From: [REDACTED]
Sent: 13 January 2014 14:56
To: [REDACTED]
Cc: Nikolas Antoniou; Roger Spencer; Daniel Vick
Subject: RE: BR/272/13 on Wednesday 15th January 2014

BR/272/13 for consideration on Wednesday 15th January 2014

The planning application is for a beach ramp at Bognor Regis Yacht Club which is well supported with no objections.

LOCATION PLAN 'ISSUE B'

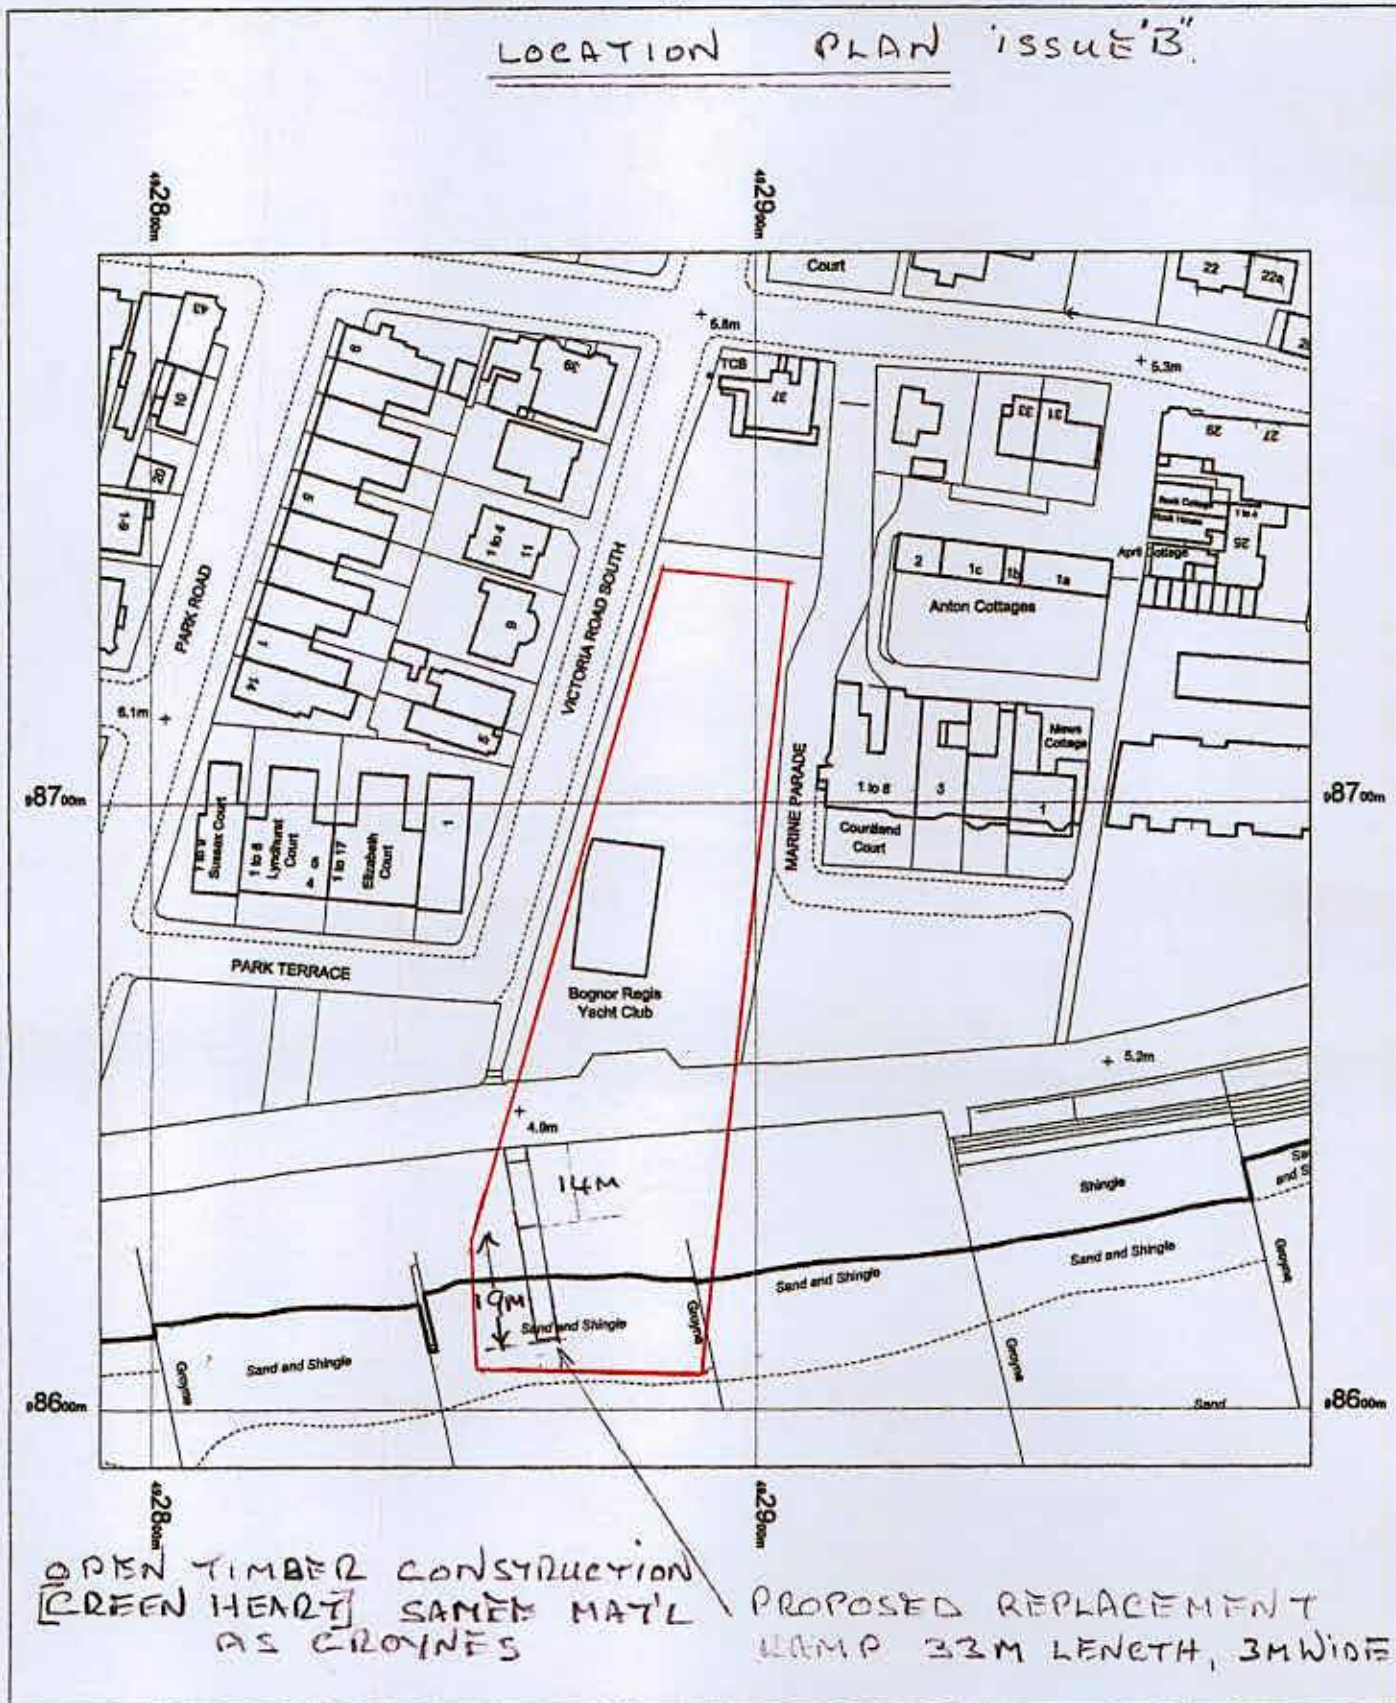
I note your concerns regarding the request by Natural England to shorten the ramp. Unfortunately, I am duty bound to follow their advice as they are our statutory consultees and the experts in terms of the potential for impact to the Site of Special Scientific Interest (SSSI). Hence I requested that Mr Elwin submit an amended plan to shorten the length of the ramp. This he did so in late December 2013.

Roger Spencer has been most helpful with design and advice on this proposal but the plan going forward makes the ramp approx. 2 metres shorter and with a slightly steeper incline than originally designed.

This is because Natural England (Natural England measures requested item 1.) does not wish the ramp to extend past the nearby outfall pipe.

LOCATION PLAN 'ISSUE C'

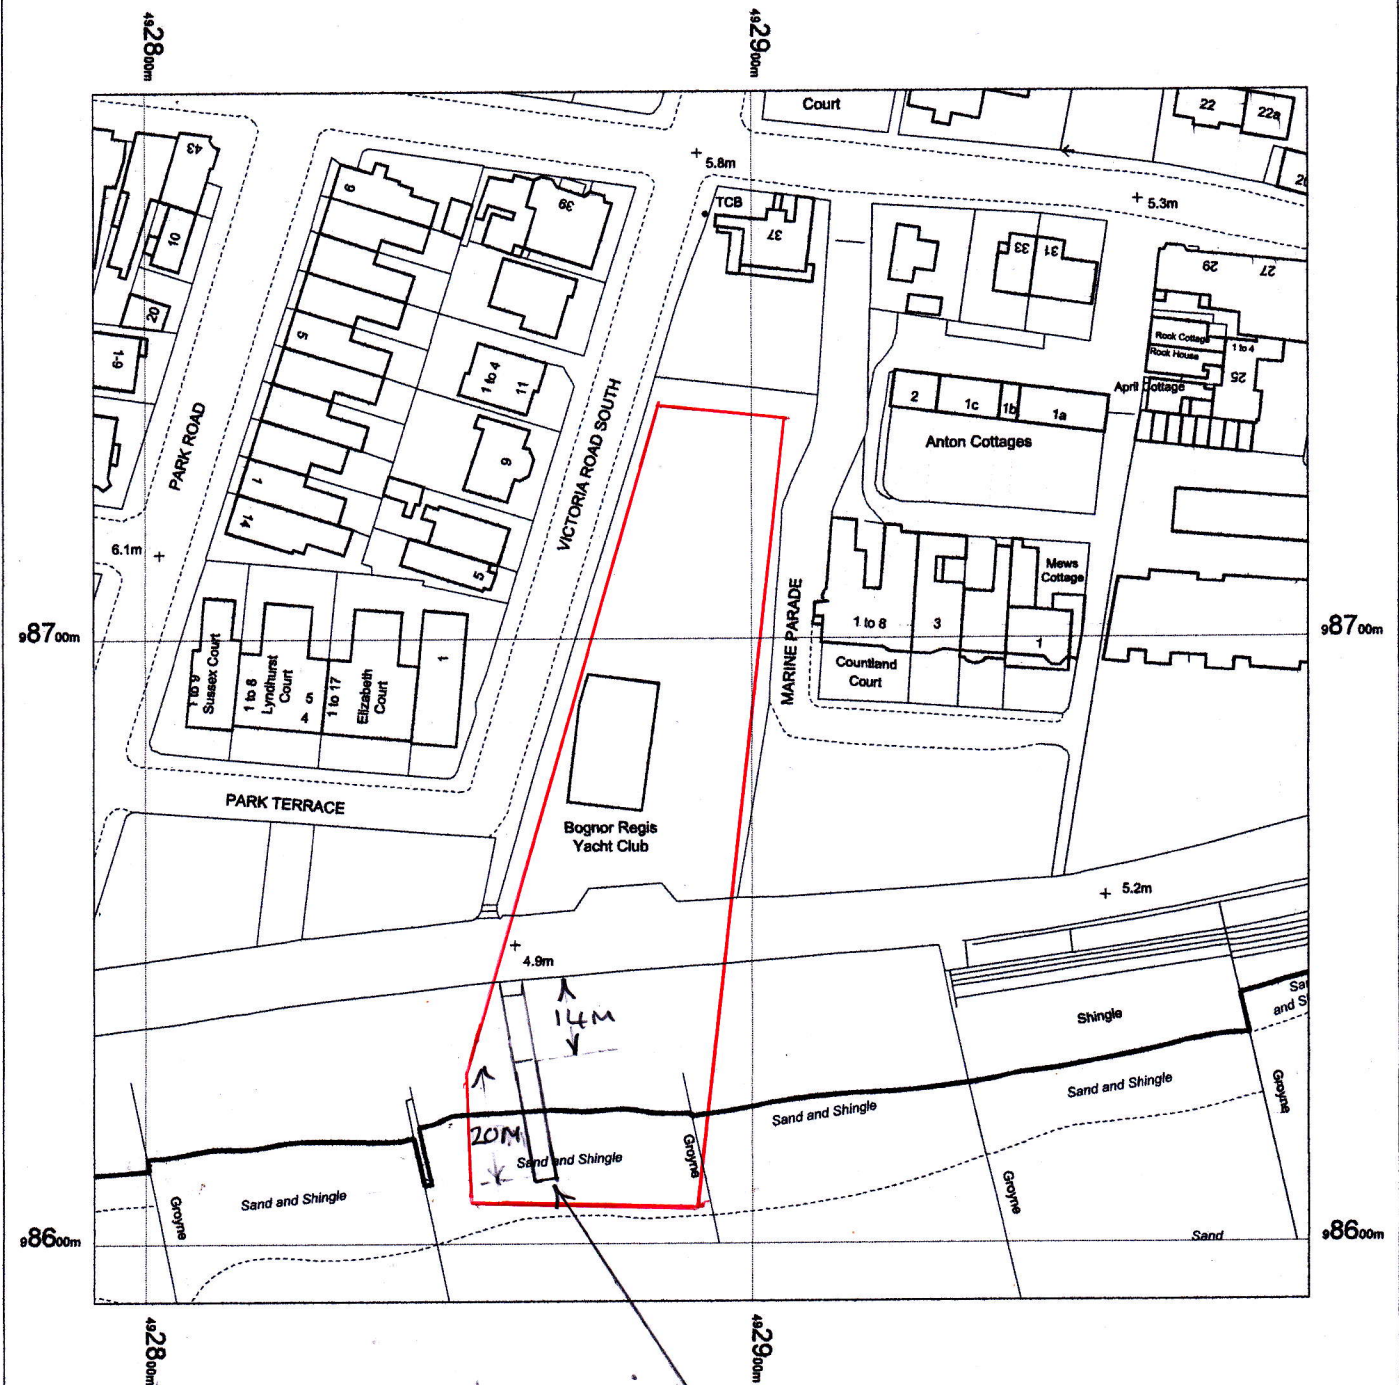
I have been in contact with Mr Elwin since the receipt of the Natural England comments and I understand his concerns repeated in your email about shortening the ramp. Indeed, I understand that he spoke with Natural England today and that Natural England have agreed to consider a compromise solution of allowing the ramp to extend a metre beyond the outfall pipe. I have advised Mr Elwin by telephone today that an amendment can be made as long as the amended plan is received by end of play tomorrow (the deadline for amendments is 10am on Wednesday) and that I will also require something in writing from Natural England.

As to your last question, this does not seem to be an issue if (as expected) Natural England do agree to the extra 1 metre (as Mr Elwin has also agreed to this). However, the planning committee would be able to agree to the full extra 2m if they so wished although I would recommend not making a decision against the advice of Natural England as should damage to the beach (& SSSI) occur then ultimately the Council could be responsible. The original drawings submitted do show the ramp with the extra 2m so we would not need a new plan submitting to show this – rather we would just need to alter the plans condition to reference the previously superseded drawing.
